CITY OF ALBUQUERQUE

March 31, 2017

**RE: Paseo Marketplace
Conceptual Grading Plan
Stamp Date: 3/2/17
Hydrology File: D18D056**

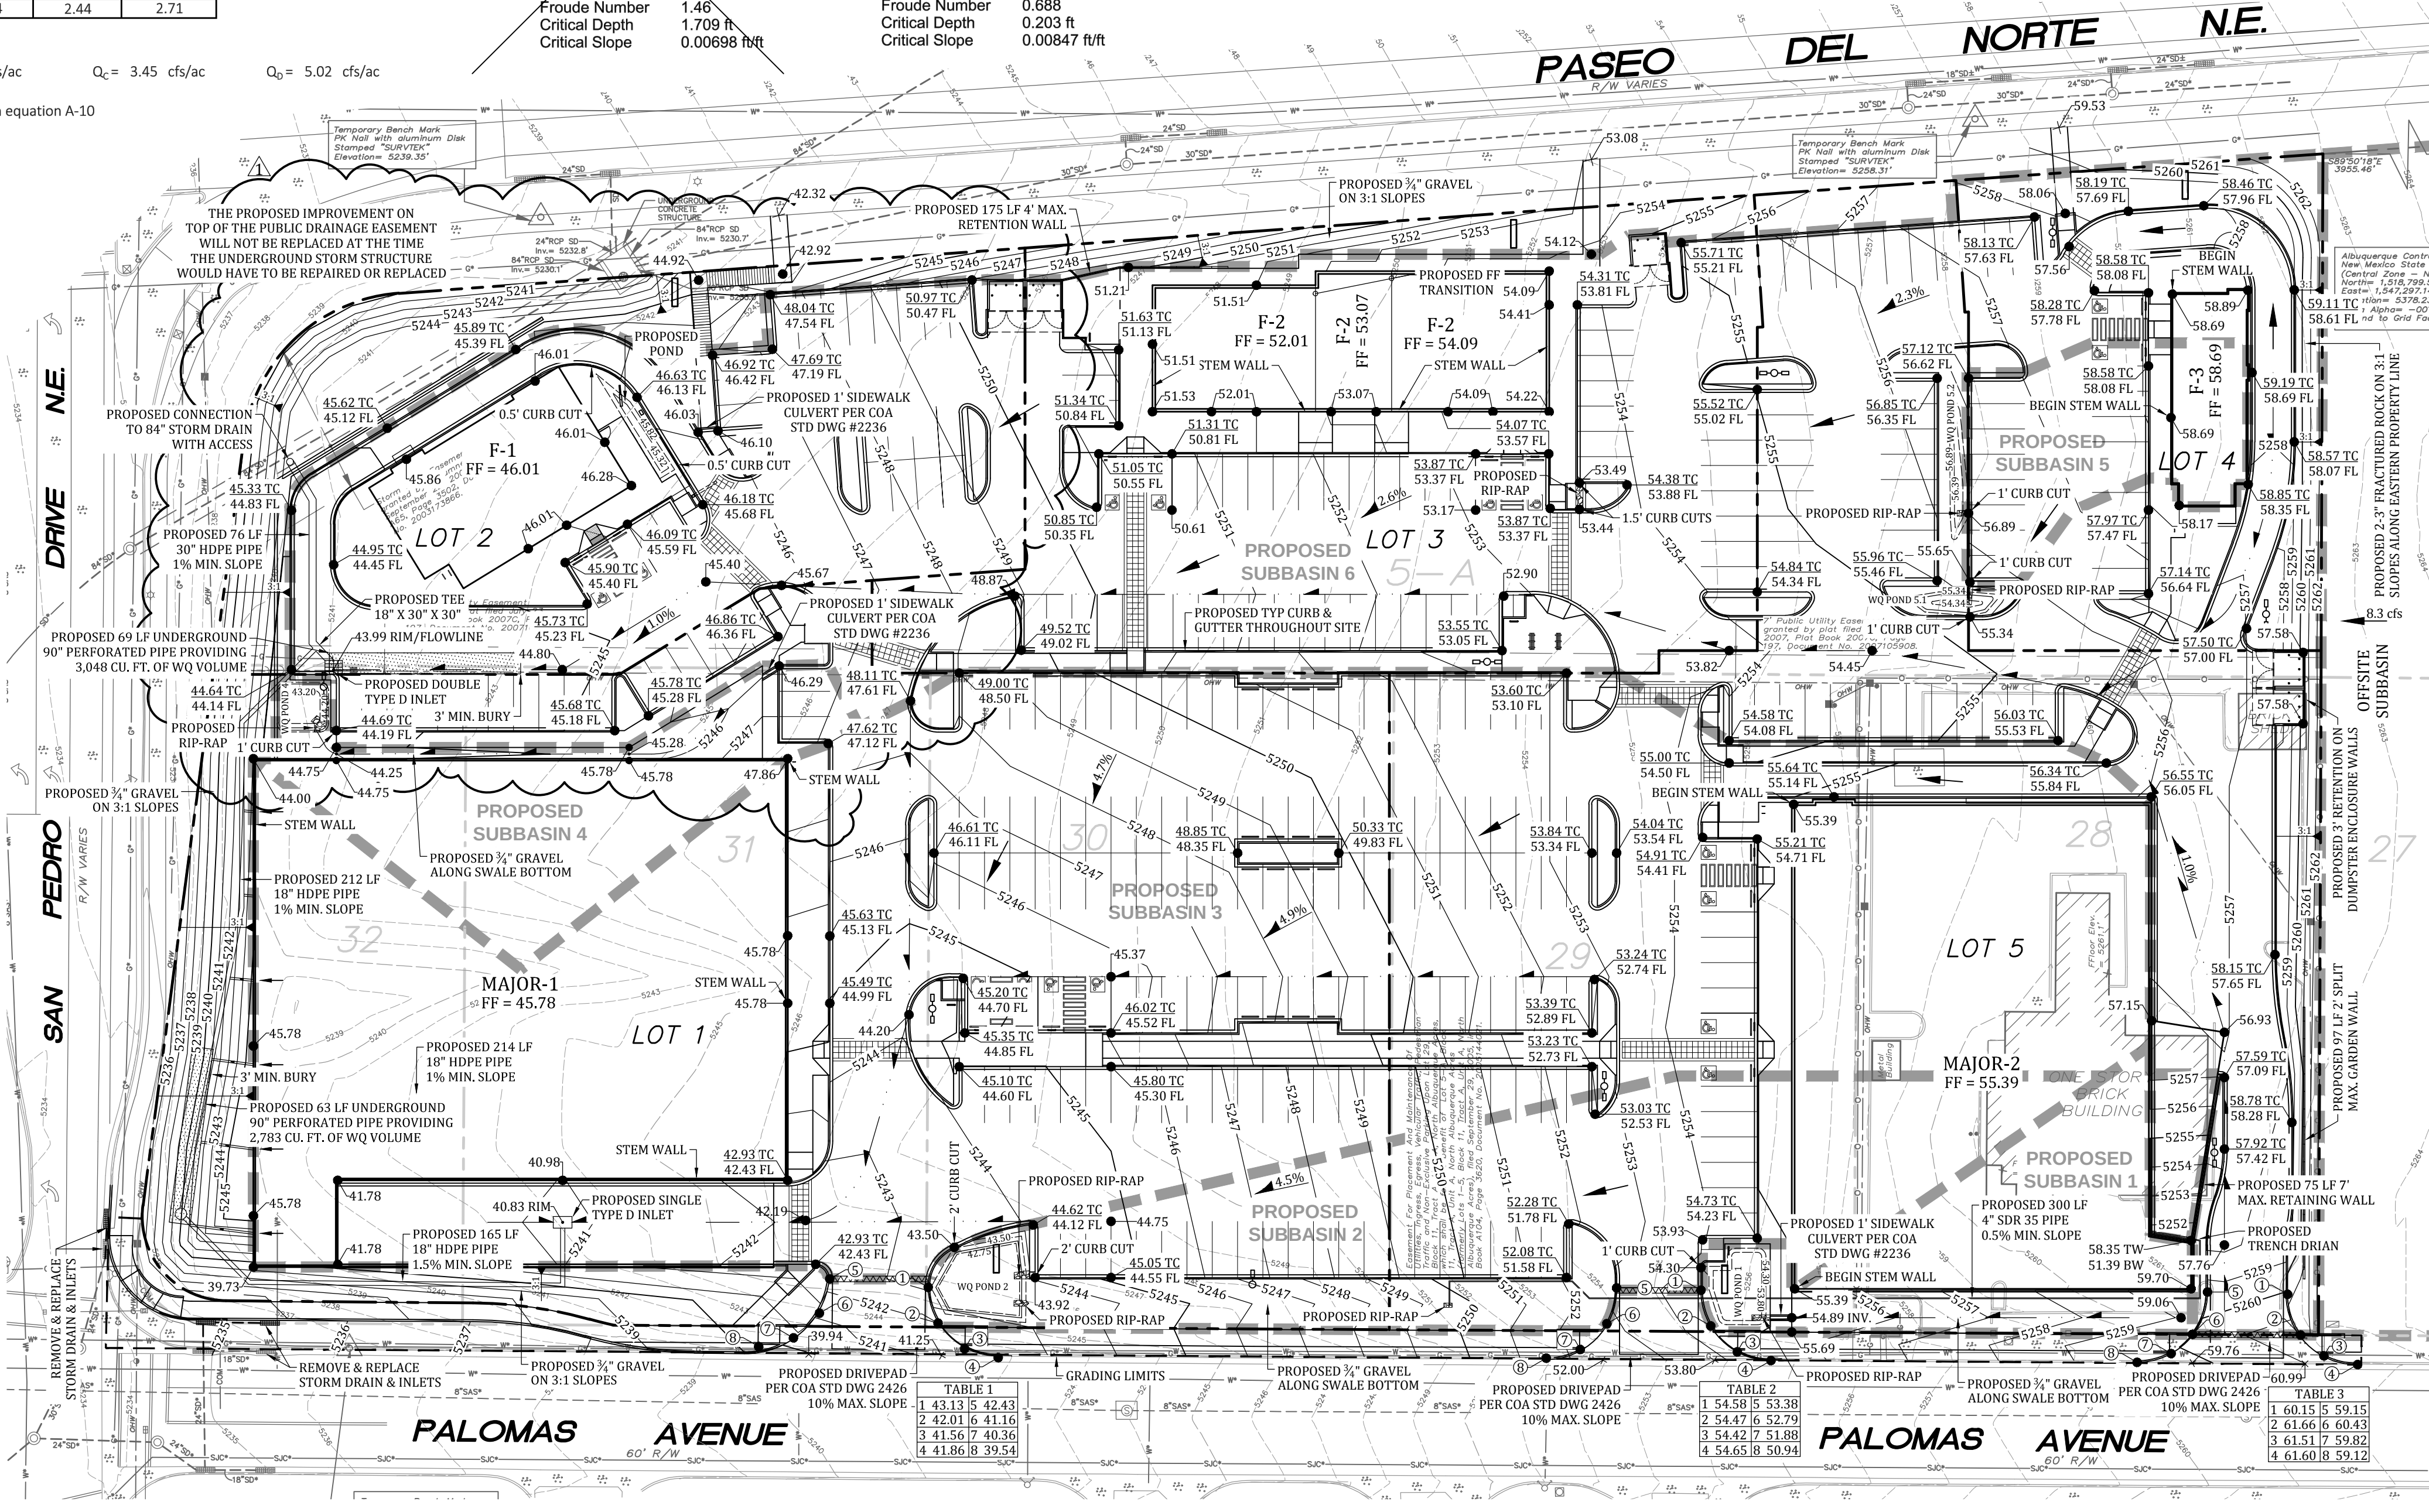
2. For your water quality pond for the subbasin 1, you are proposing a fire dept conn. for Bldg Major-2. Please shift this closer to the building and out of the water quality pond.

5. For the proposed truck ramp, you call out a 4" NDS grate. I'm concerned about clogging of this inlet. Typically for a truck ramp, one places a French drain which can be easily cleaned out and if partially clogged, it will still function. You might want to take another look at this.
6. In Proposed subbasin 6, you have one building listed as Food. Just a reminder that for the drainage from the dumpster for this building will need to drain into the sanitary sewer.
